Site plans - building permit

Dominic, Pat, Adam,

3. NO PARKING SPOTS ON NORTH SIDE OF CONGRESS STREET
4. TURNER NEEDS 10 FEET ON GILMAN STREET.
5. REFER TO CMP SECTION 3.0 FOR GARAGE REMOVAL METHODOLOGY.

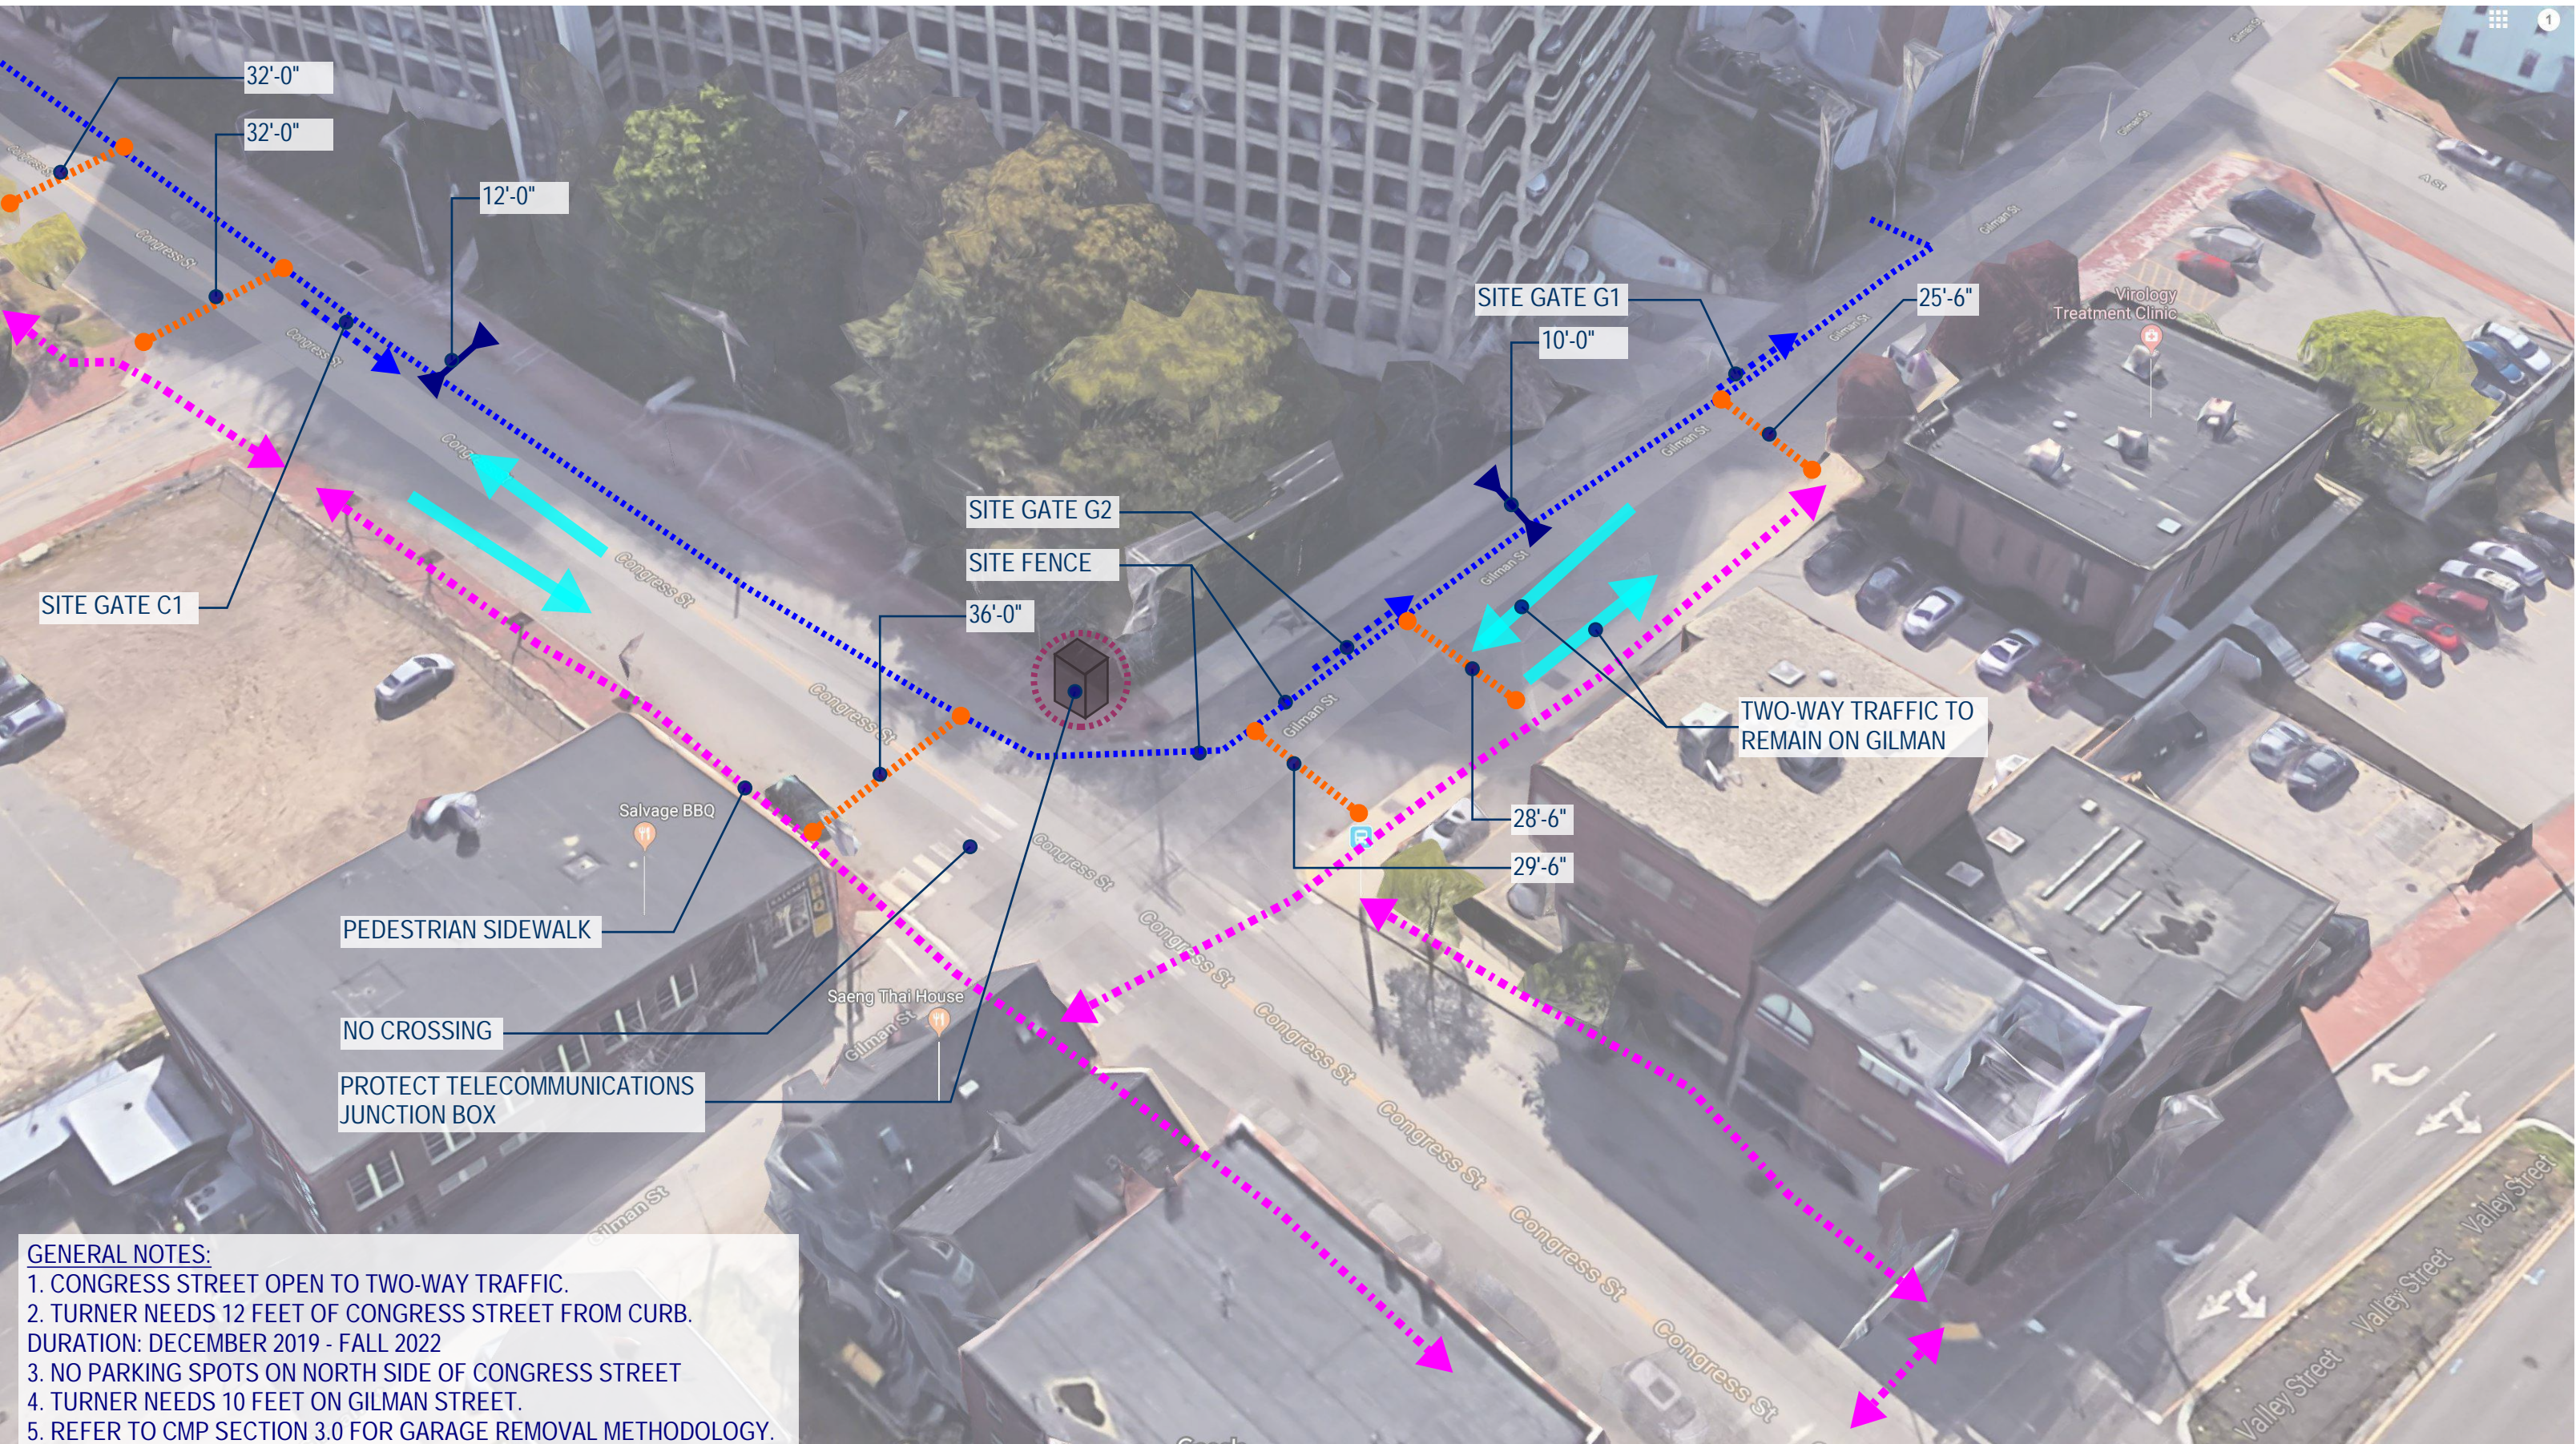
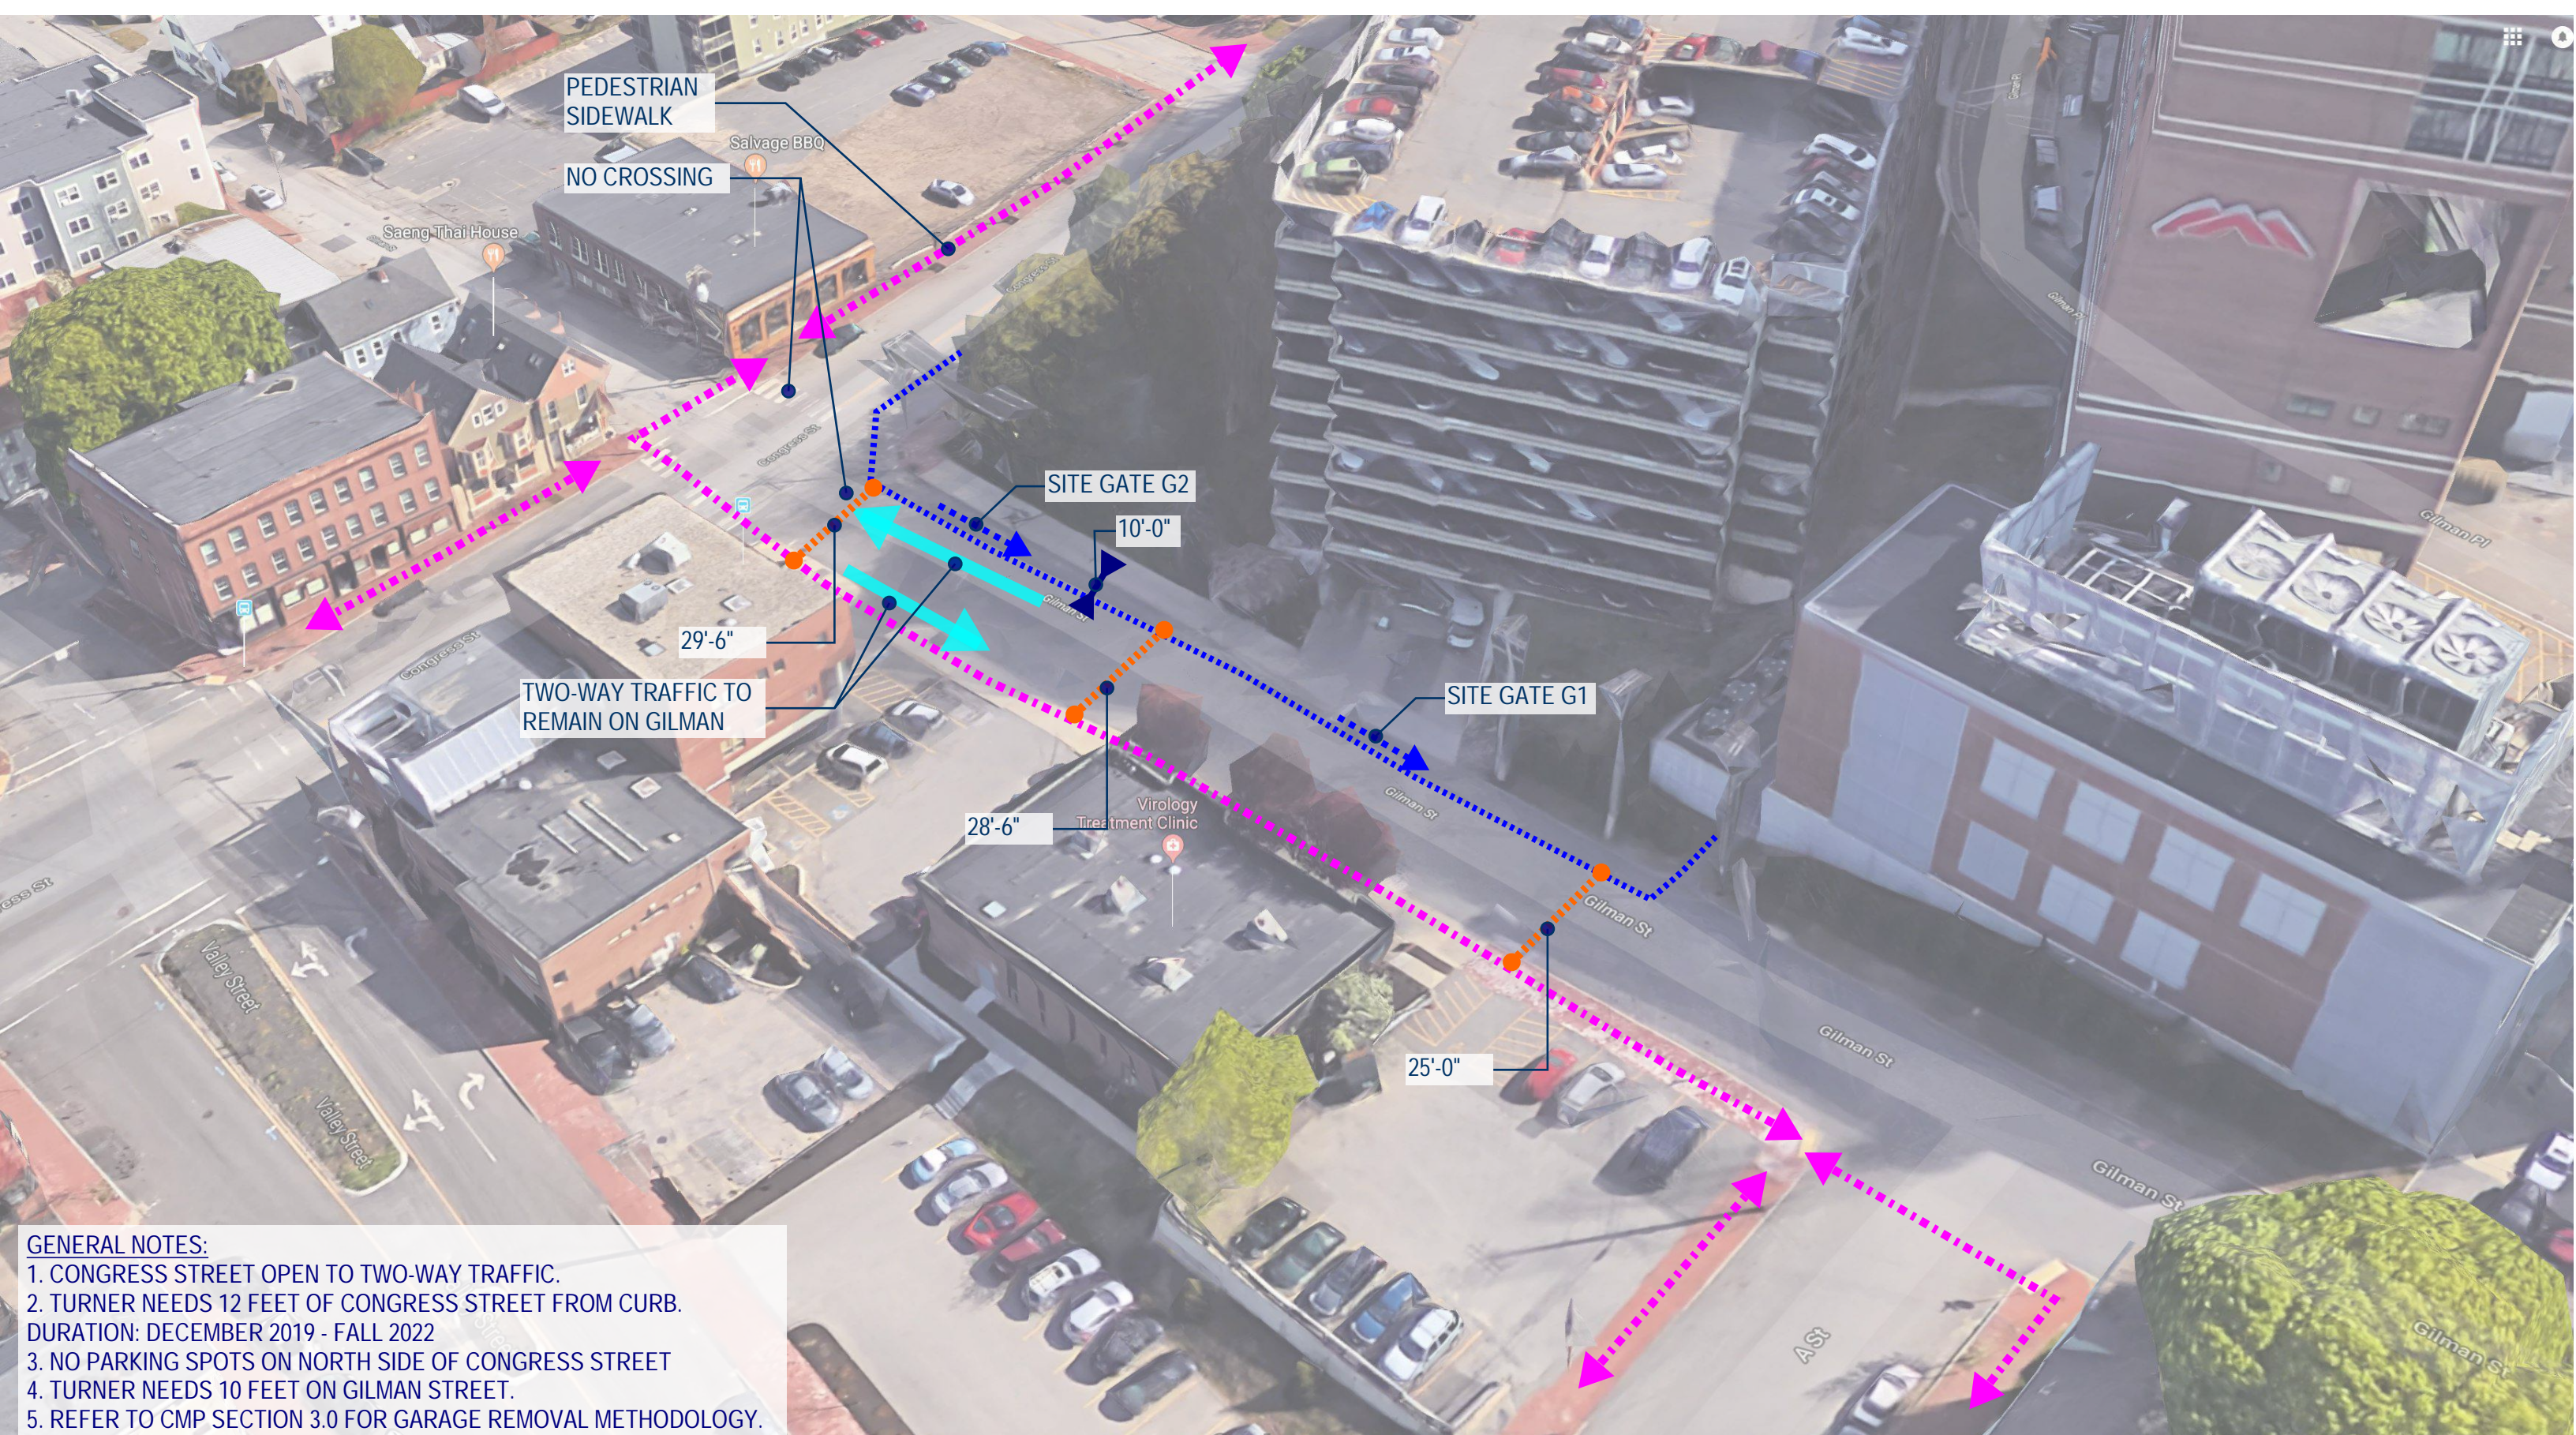
We also have no updated logistics plan since the original CMP submittal in November 2018. There are references to logistics plans in the CMP you've provided here, but no attachments. (See the latest version that we have (not including the package for the enabling work) attached.) Can you provide updated logistics plans if there are any?

It is recommended that further discussion on the duration of the Congress Street sidewalk closures be included. Supplemental pedestrian safety devices will be required during the sidewalk closure time period (to safely cross pedestrians for the sidewalk detour).

All sidewalk detours shall be ADA compliant.

Changes to the lane configuration on Congress Street west of Gilman Street is likely and may need to be included in the plan.
